From: Marlow, Angela [REDACTED]
Sent: 30 September 2021 18:21
To: Tom Day [REDACTED]
Cc: Scott-Heagerty, Tom [REDACTED] Seymour, James
[REDACTED] angela.marlow [REDACTED] Simon Davis
<Simon.Davis@arun.gov.uk>; Joanne Prichard [REDACTED] Shore, Emma
[REDACTED] Clarke, Adrian [REDACTED] Hasler,
Luke [REDACTED]
Subject: NE's comments - HRA for applications P/93/21/PL (Arun DC) and 21/01921/FULEIA (Chichester DC)

Habitats Regulations Assessment for Planning Application References P/93/21/PL (ADC) and 21/01921/FULEIA (CDC)

Drawing B

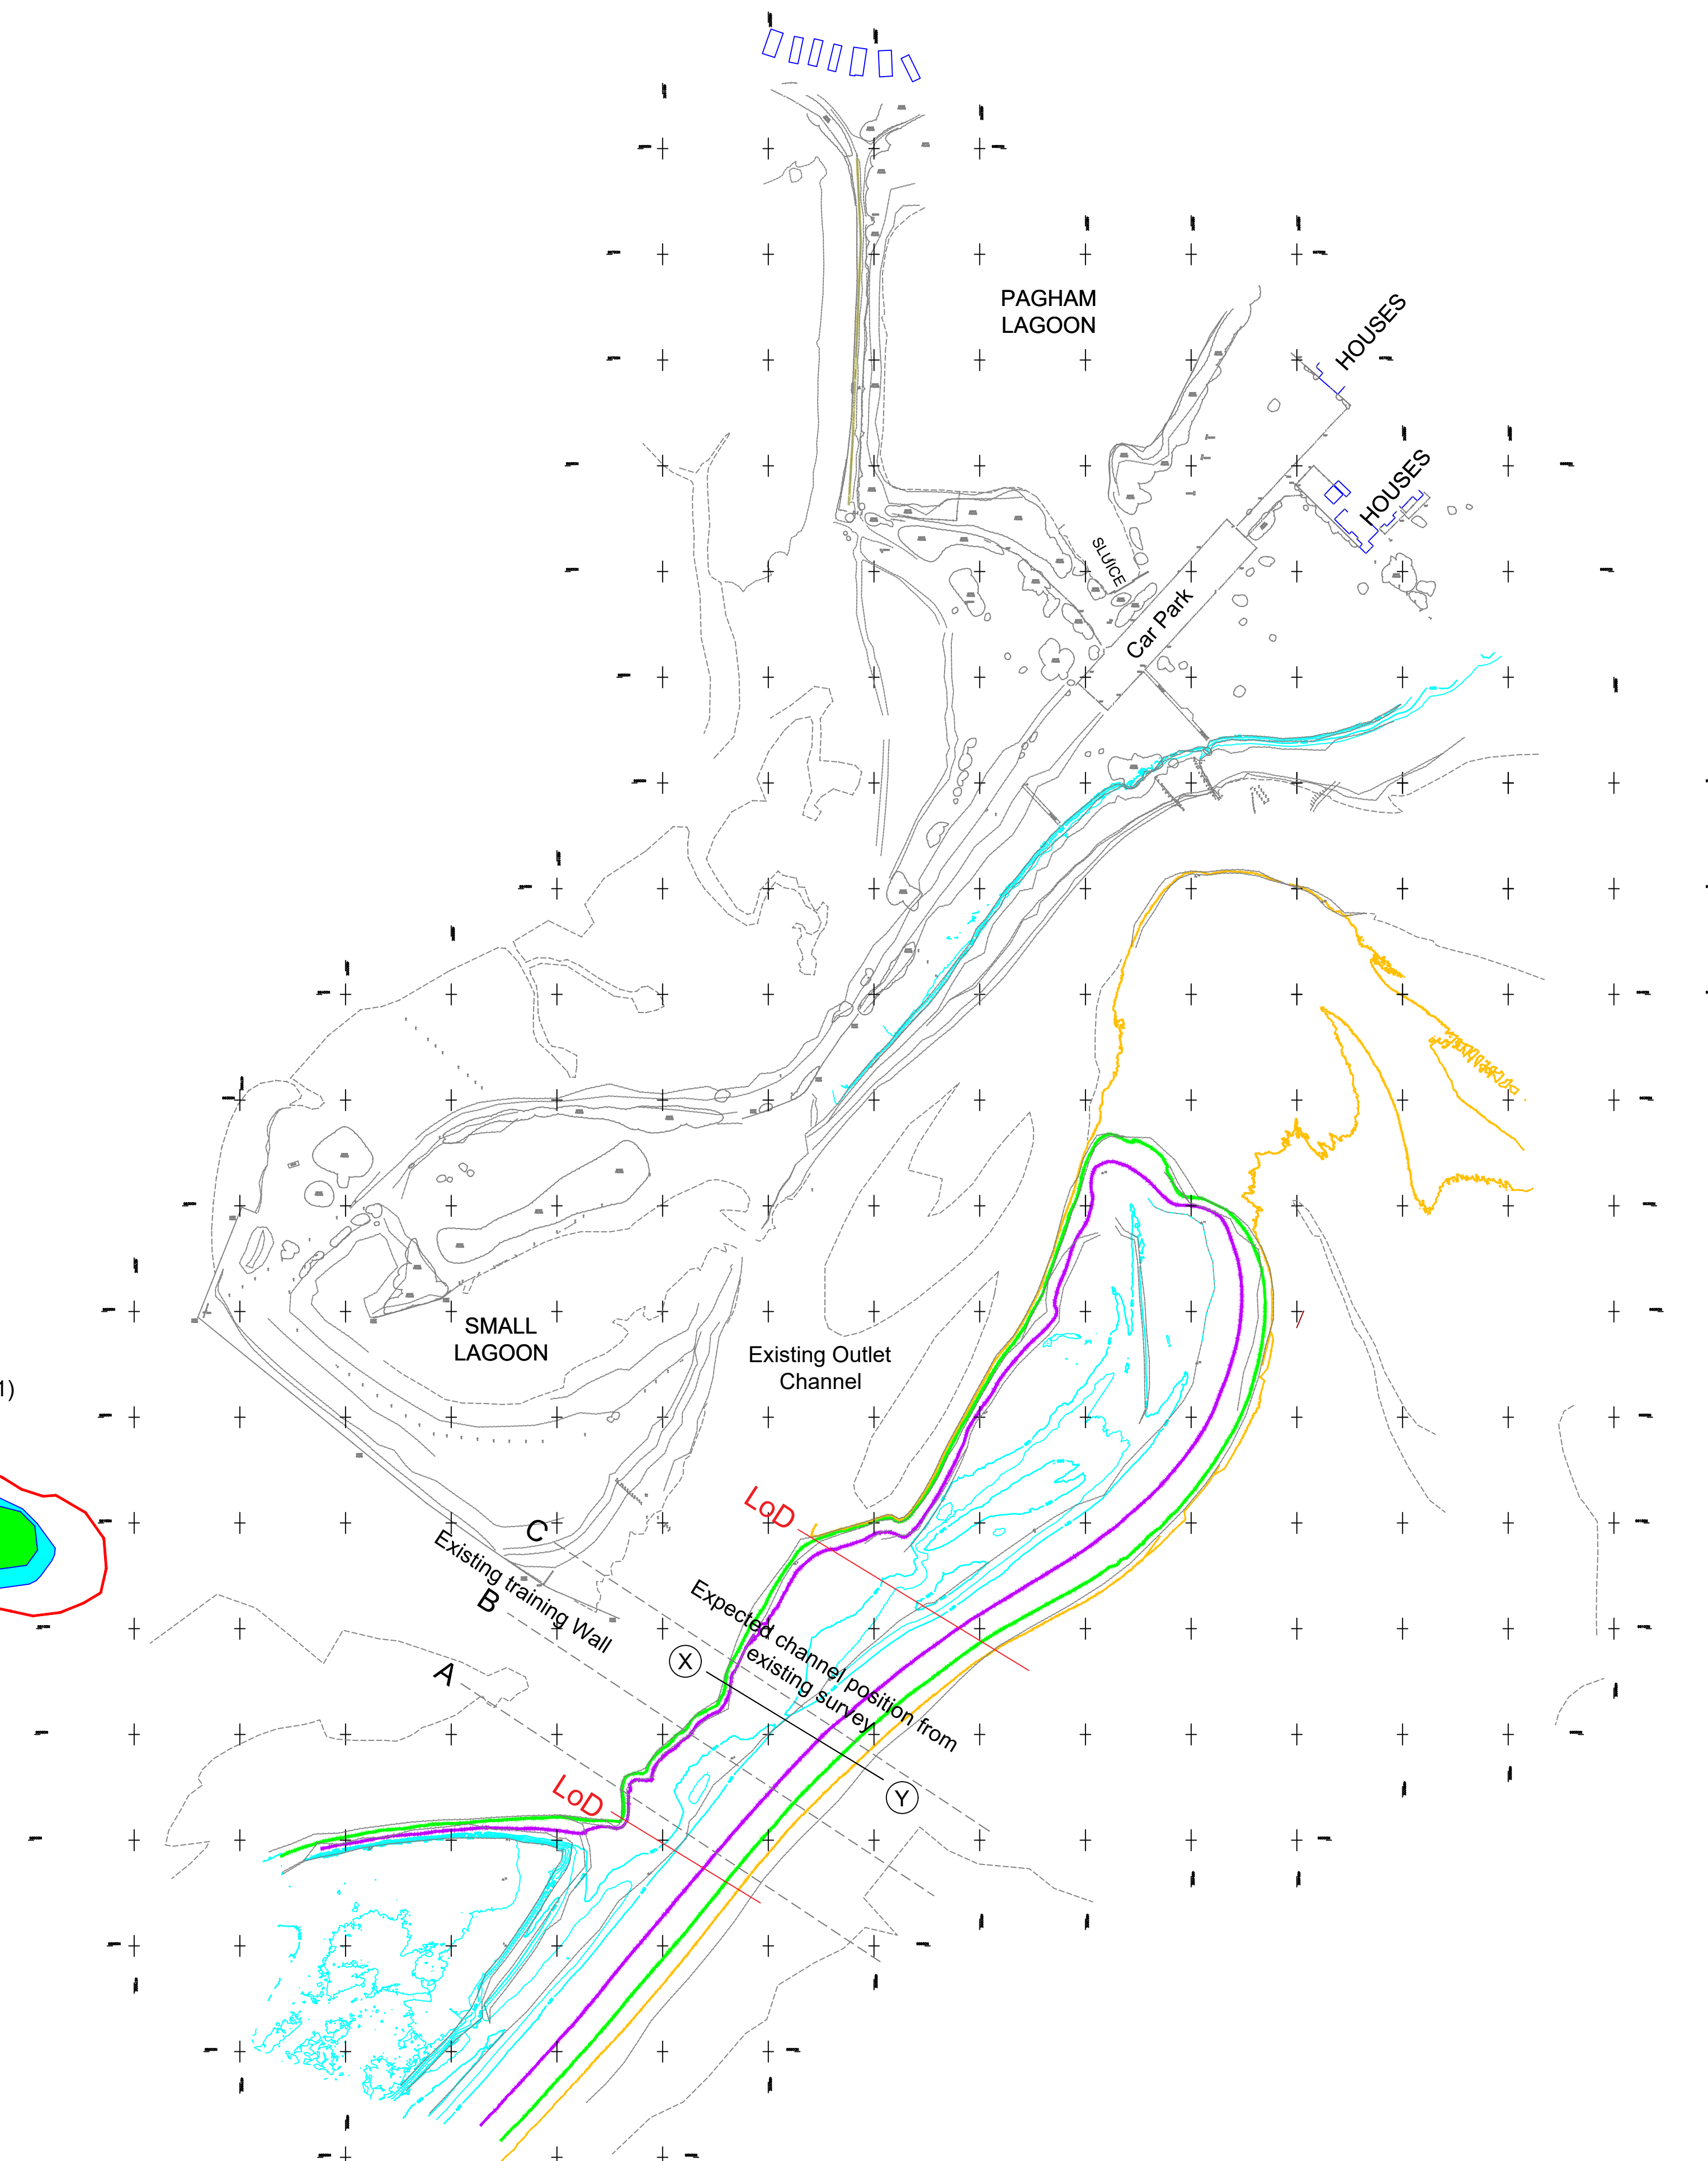
Commented [MA3]: In our advice letter we said Natural England note that the Construction Management Plan detailing the operations to breach the spit, and to create the compensatory little tern island has not been submitted at this time. This information is required before the commencement of work relating to the breach taking place. Have we seen this additional information about the compensation?

Commented [MA20]: This is the size of the compensation it needs to support the little tern population that was 15 pairs at designation, this year was 46 pairs

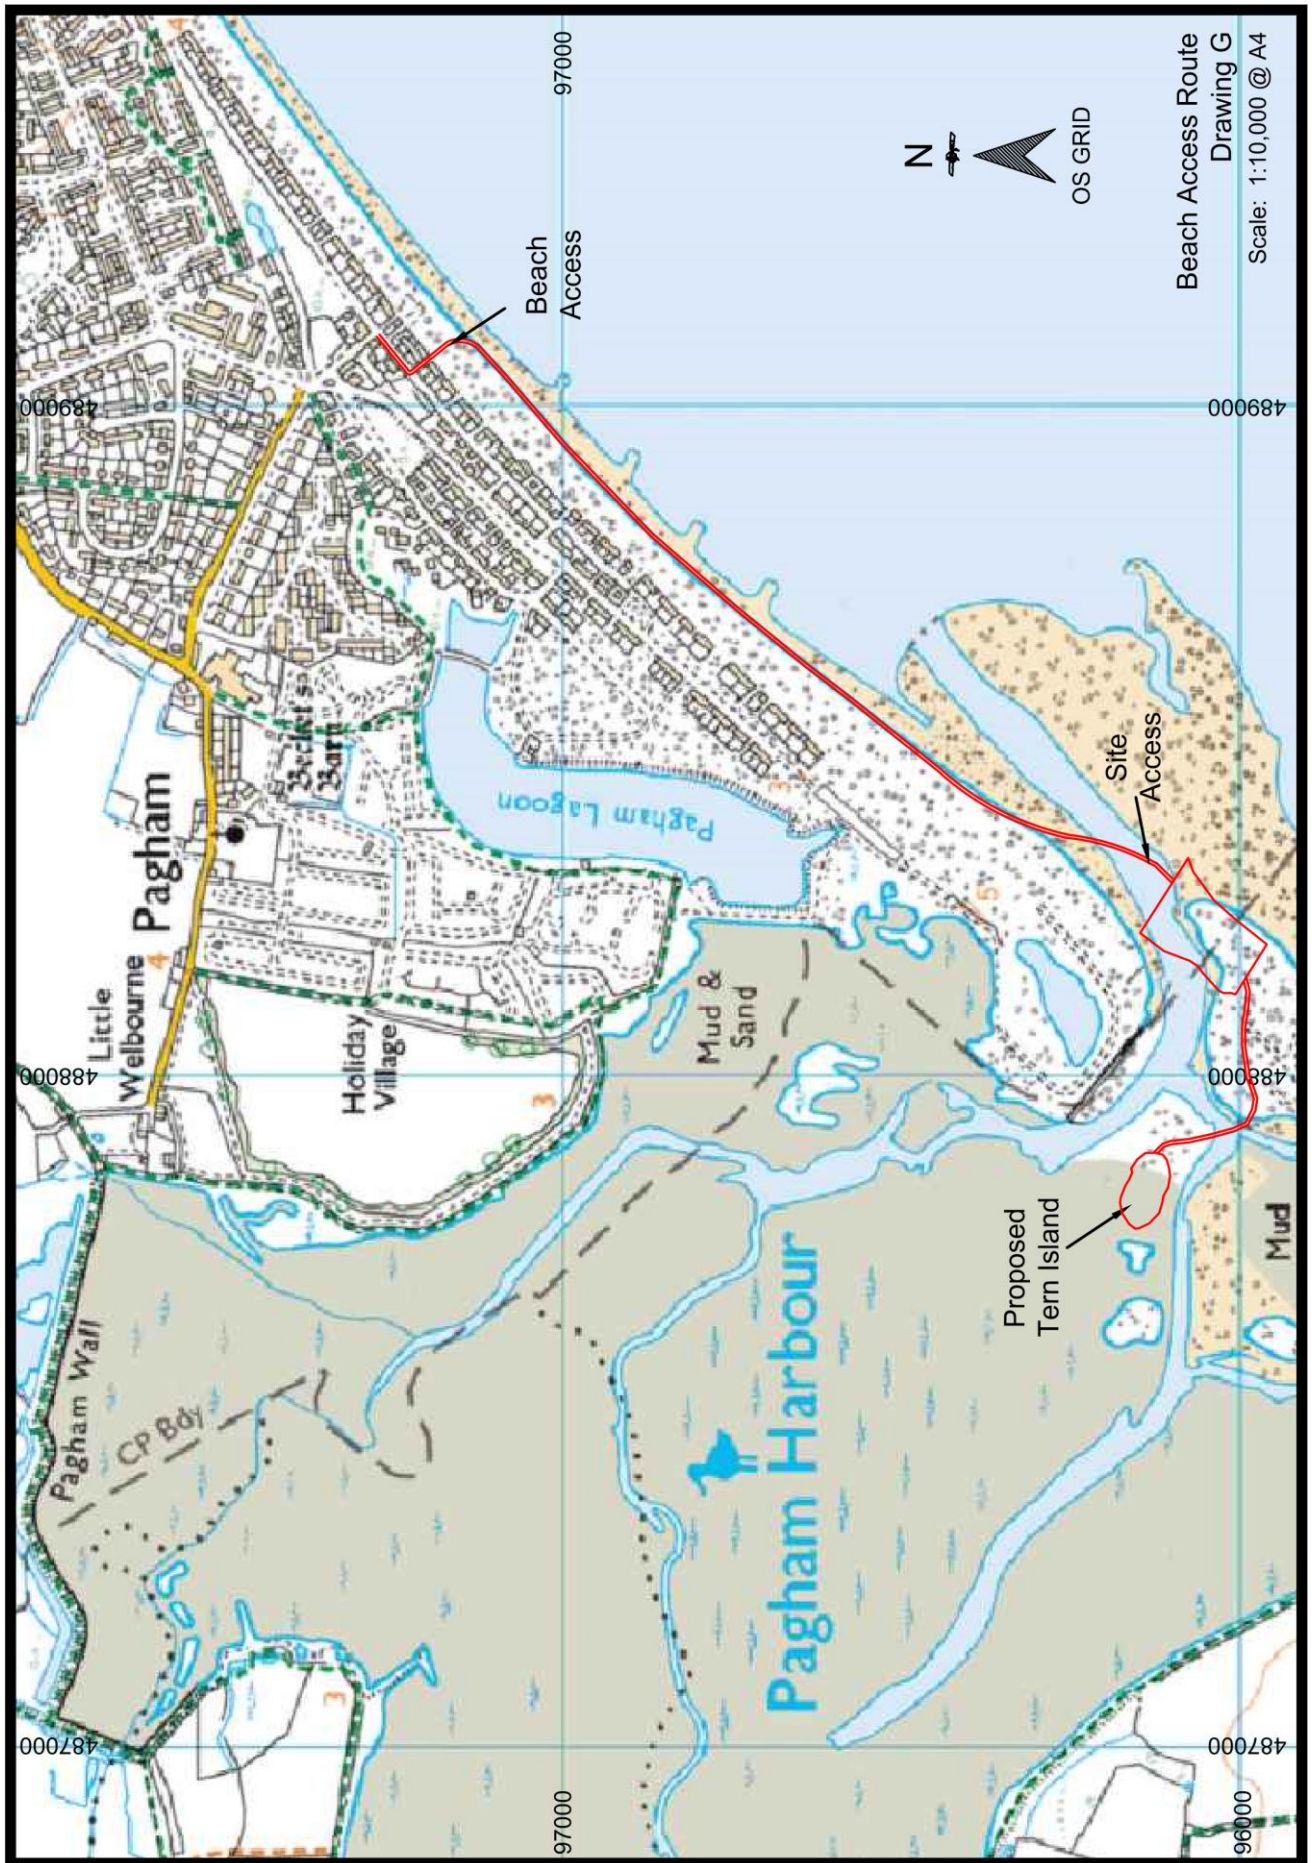
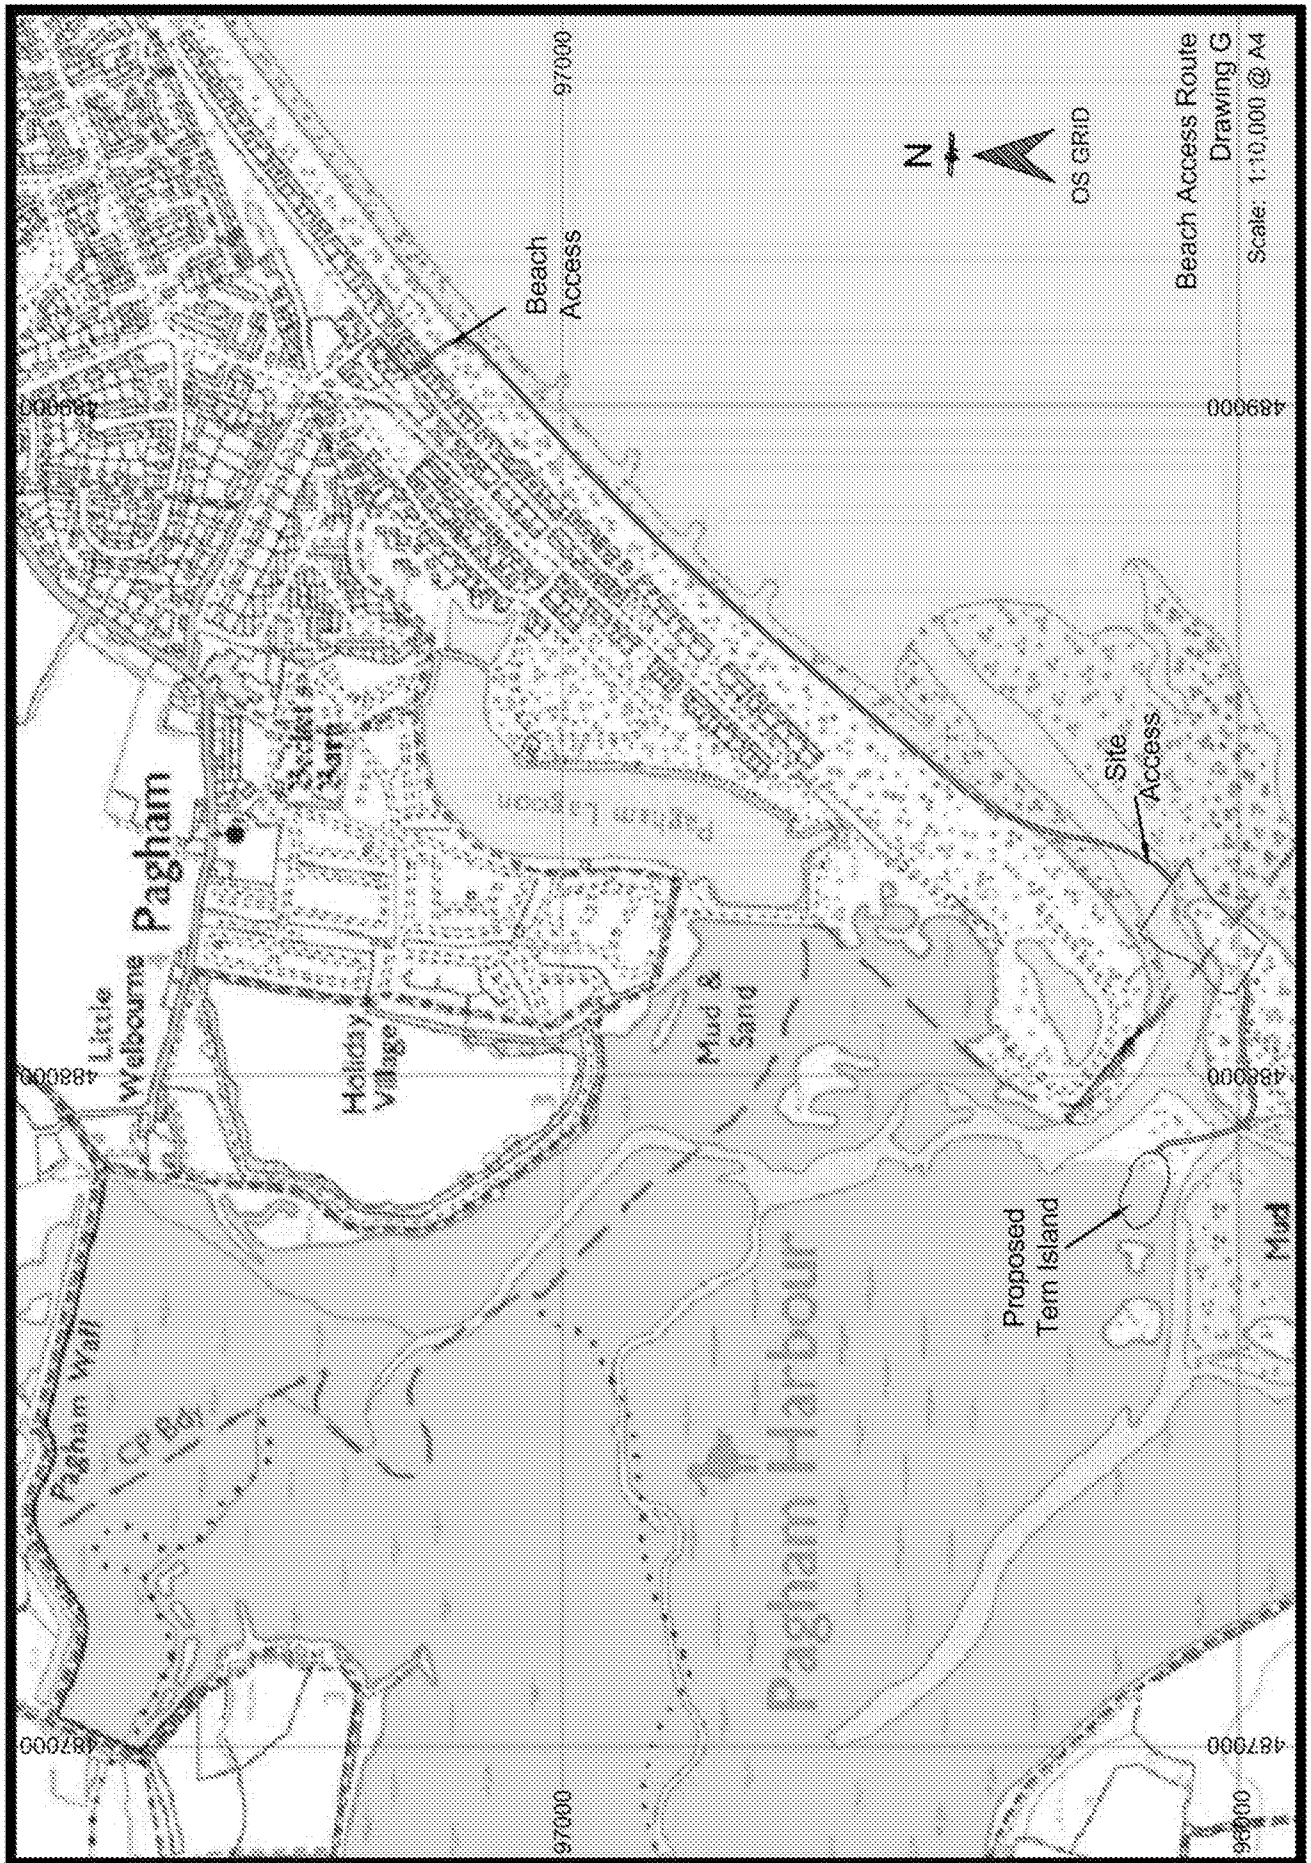
Commented [MA7]: Yes you can only consider mitigation measures and habitat creation within a site on site fabric is not considered mitigation. Any proposal with significant loss of habitat needs to go through the derogation tests.
